RE: **Beehive Homes**
Grading & Drainage Plan/Report
Engineer's Stamp Date 9-8-2016 (File: E10D027)

Based upon the information provided in your submittal received 9-15-2016, the above referenced Grading and Drainage Plan and Report is approved for Building Permit with the following condition:

SHEET TITLE	
PHASE I GRADING PLAN	
SHEET NO:	
C-3.0

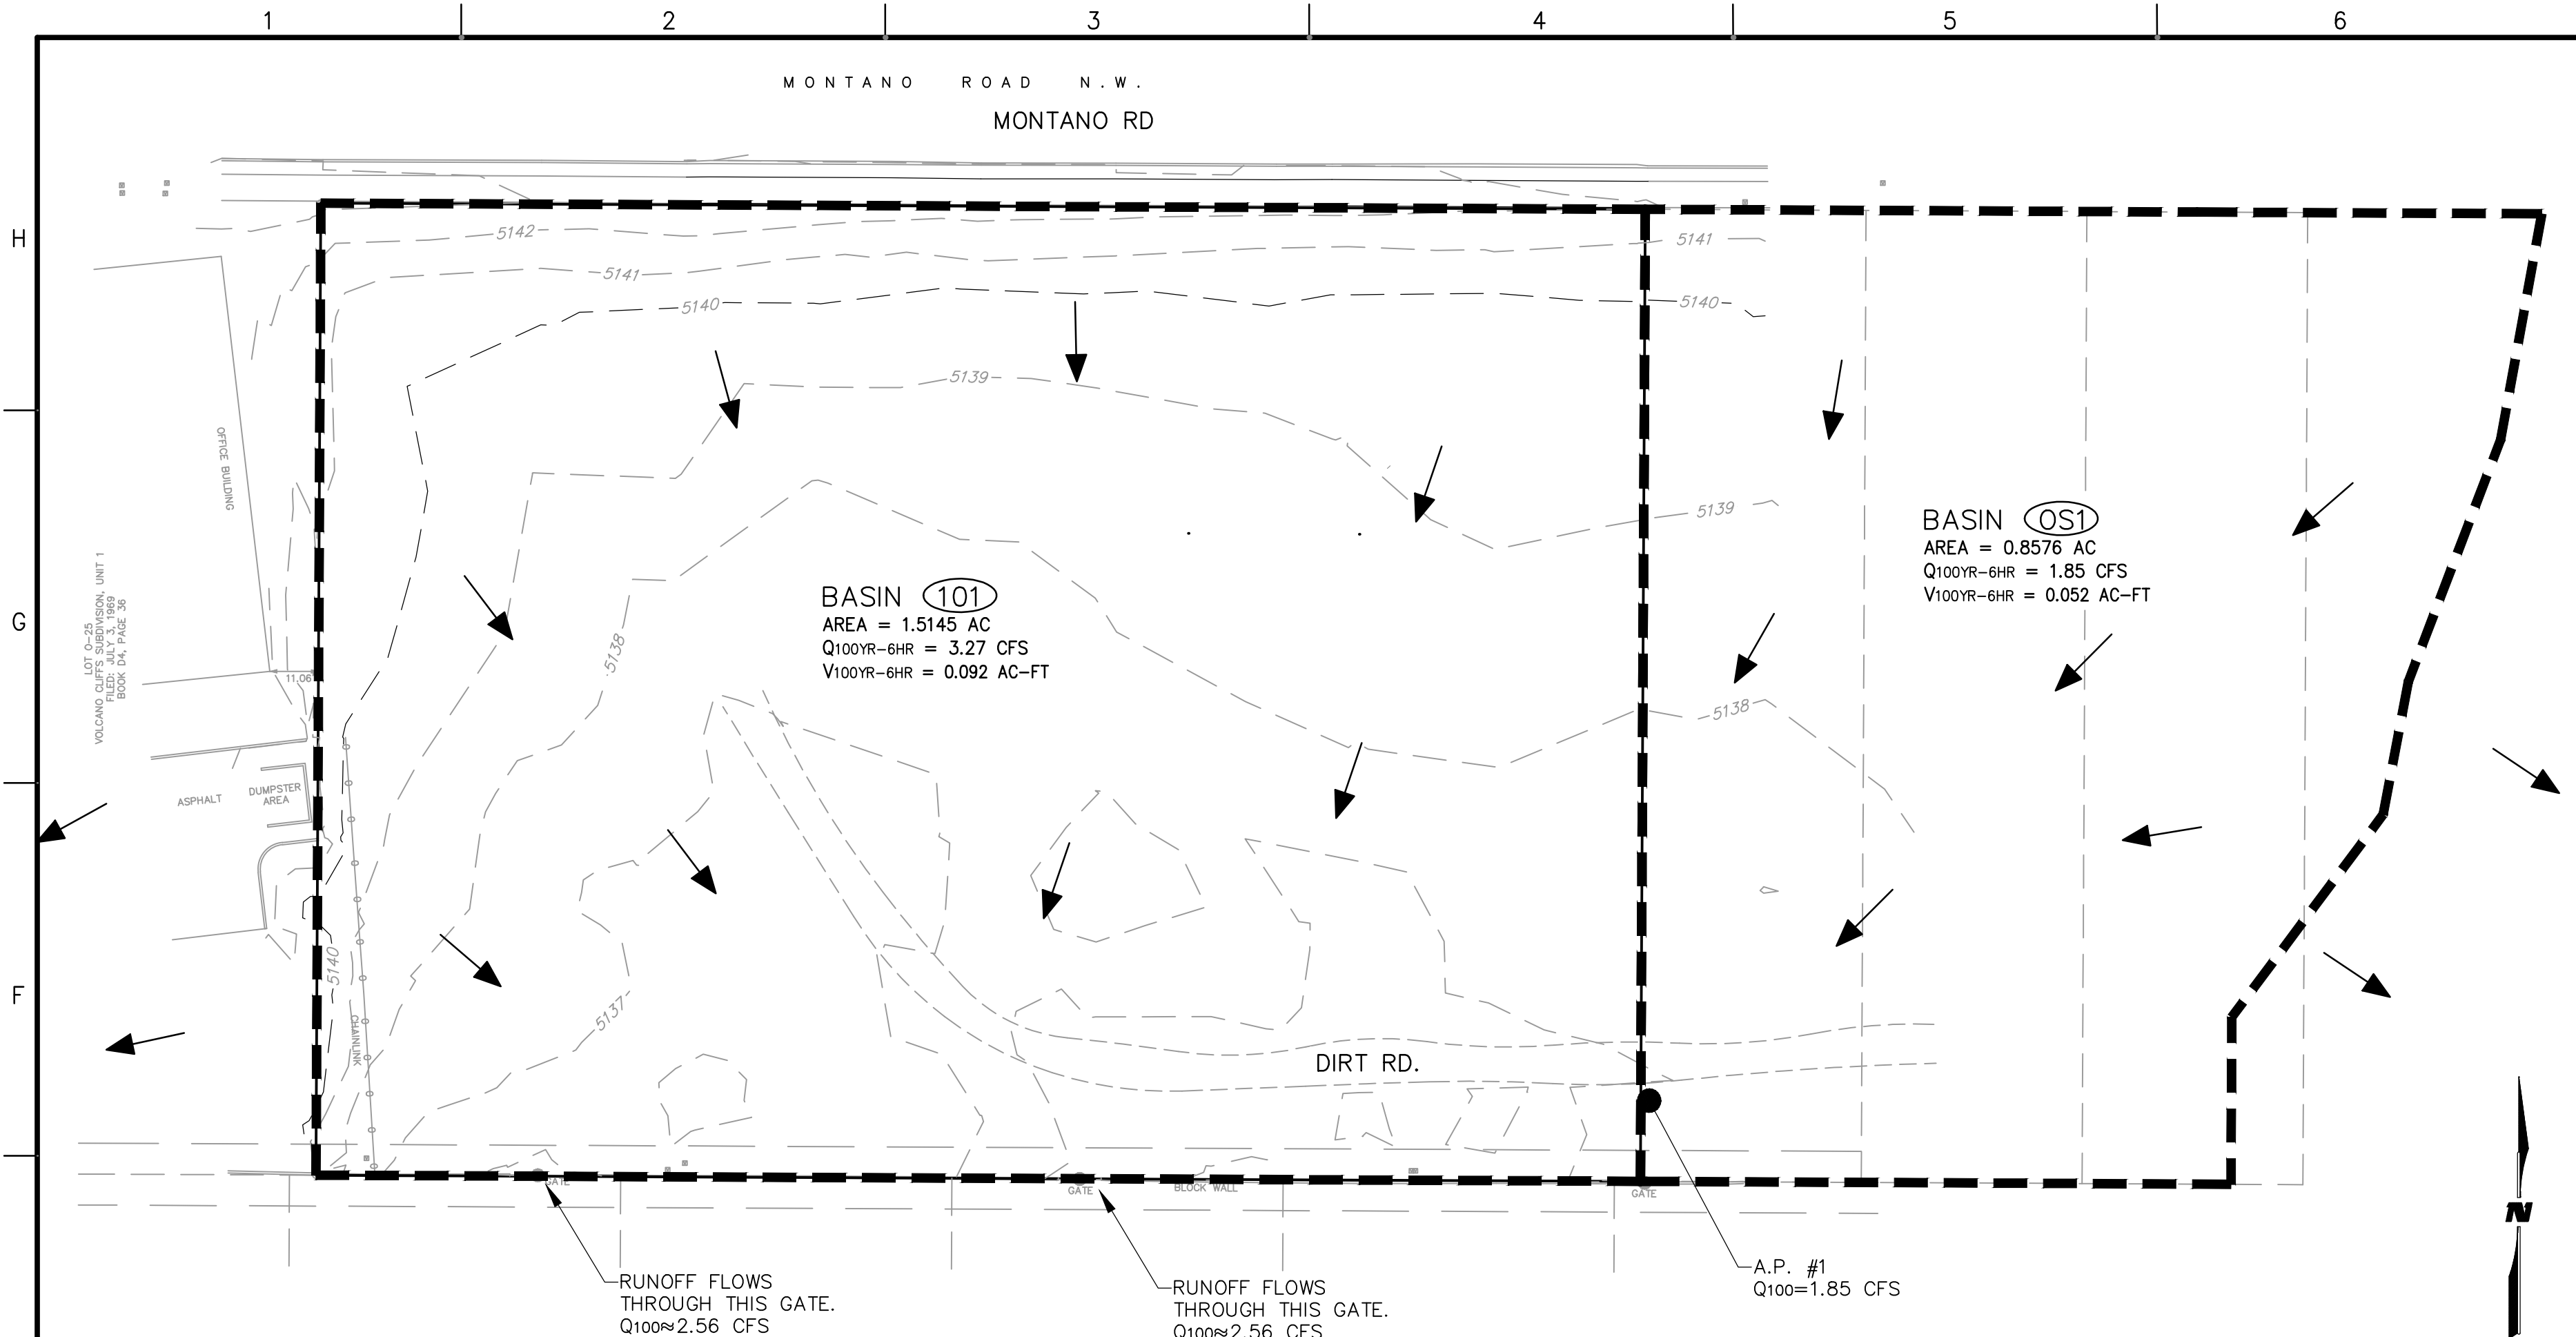
- Provide a desiltation pond, or other method to decrease sediment transport onto the adjacent property, since much of the existing on-site vegetation will be cleared with Phase I.
